***Planning Department  
Transportation Development Services***

February 2, 2015

**Re: Starbucks and Burger King, 1000 Rio Grande Blvd. NW**  
**Traffic Circulation Layout**  
Engineer's Stamp dated 01-16-15 (H13-D021)

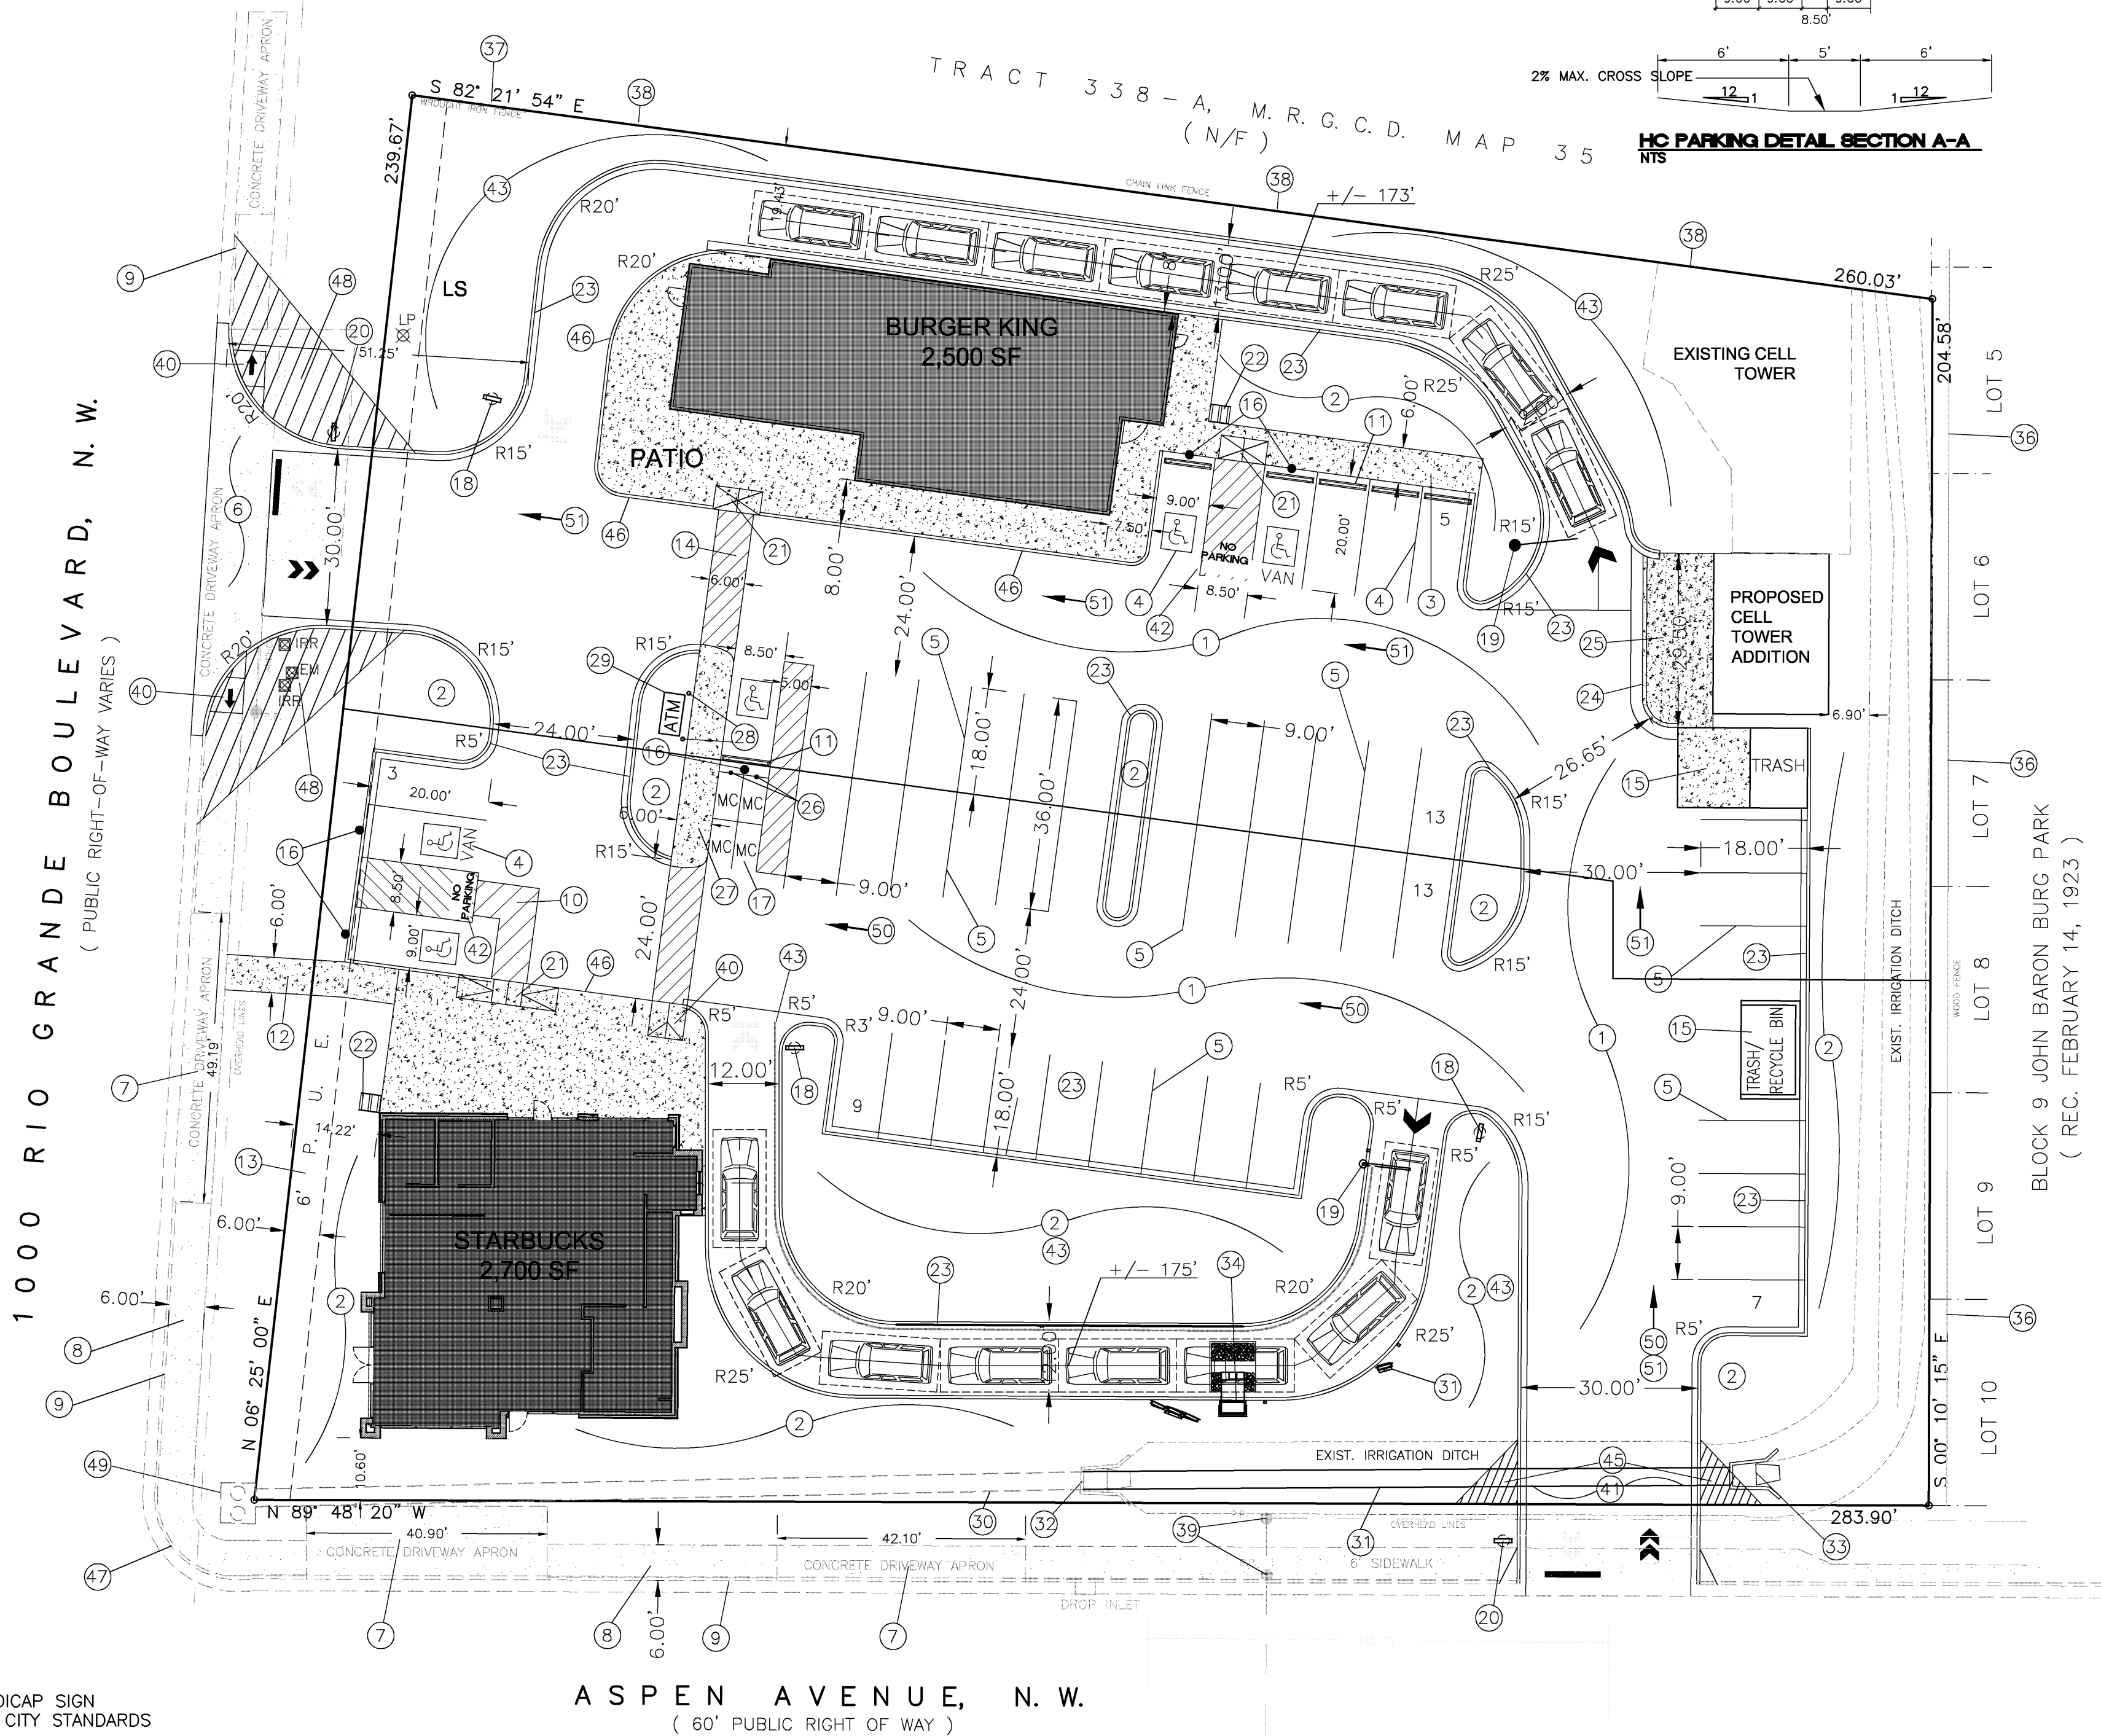
2. Label existing curb ramp at the corner of Aspen Avenue and Rio Grande Blvd. Call out for it to remain undisturbed.
3. Label curb radii for all dead-end islands. Radii needs to be a minimum of 15 feet for passenger cars (See Figure 23.7.2, Page 23-88 of DPM.). For the southeast corner of the site development, radii of 10 feet and 8 feet are shown, and they need to be increased to 15 feet.

4. Please show and label the Aspen Avenue/23<sup>rd</sup> Street intersection to show the proximity of new drivepad location to this intersection.
5. The drive onto Rio Grande Blvd. does not meet the required queuing throat length for an arterial street (Table 23.7.1, page 23-91). The throat will have to be lengthened. It's best to call and discuss this comment.

6. The design delivery route for the larger delivery vehicles needs to be shown.
7. At the northwest corner of Burger King, add curb or barrier to separate pedestrian traffic from vehicular traffic where the radius of 23 feet is shown.

8. For Notes 14, 10 and 27, increase the width of the ADA accessible route from 4 feet to 6 feet. Per the DPM, a 6-foot wide ADA accessible pedestrian pathway is required from the HC parking stall access aisles to the building entrances.

9. Provide a pavement typical section for the asphalt parking lot.

10. Show the mini clear sight distance triangle per page 23-74 of the DPM for the drivepad onto Aspen. Please add the following note to this clear sight triangle: "Landscaping and signage will not interfere with clear sight requirements. Therefore, signs, walls, trees, and shrubbery between 3 and 8 feet tall (as measured from the gutter pan) will not be acceptable in this area."

11. For the new site drive onto Rio Grande Boulevard, provide a clear sight triangle that is in compliance with Page 23-28 of the DPM for intersections. Also add the note "Landscaping and signage will not interfere with clear sight requirements. Therefore, signs, walls, trees, and shrubbery between 3 and 8 feet tall (as measured from the gutter pan) will not be acceptable in this area."

12. To provide further clarification for the queuing length for the vehicles, list the total length of the queue for both the Burger King and the Starbucks drive-thru on the site plan view.

13. For Keyed Note 7, please list the length for each one of the curb cut removals and replacements on the plan view.
14. Near Keyed Note 9, call out the existing sidewalk width. For Keyed Note 8, have call-out note saying that existing sidewalk is to remain undisturbed. Make sure Keyed Note 8 is called out on all areas in between existing curb cuts where sidewalk is supposed to remain undisturbed.

15. For the 6-foot sidewalk tie-in to existing sidewalk on Rio Grande Boulevard, call out for a smooth tie-in.
16. For the uni-directional ramps shown as part of Keyed Note 40 for the drive onto Rio Grande Boulevard, provide detail complete with detectable warning devices.

17. For Keyed Note 21, provide a ramp detail.
18. For the aisle for handicapped parking in the center of the parking lot, increase from 3.5 feet to the required minimum width of 5 feet. If it helps, in order to gain this extra width for this aisle, parking spaces only need to be a minimum width of 8.5 feet.
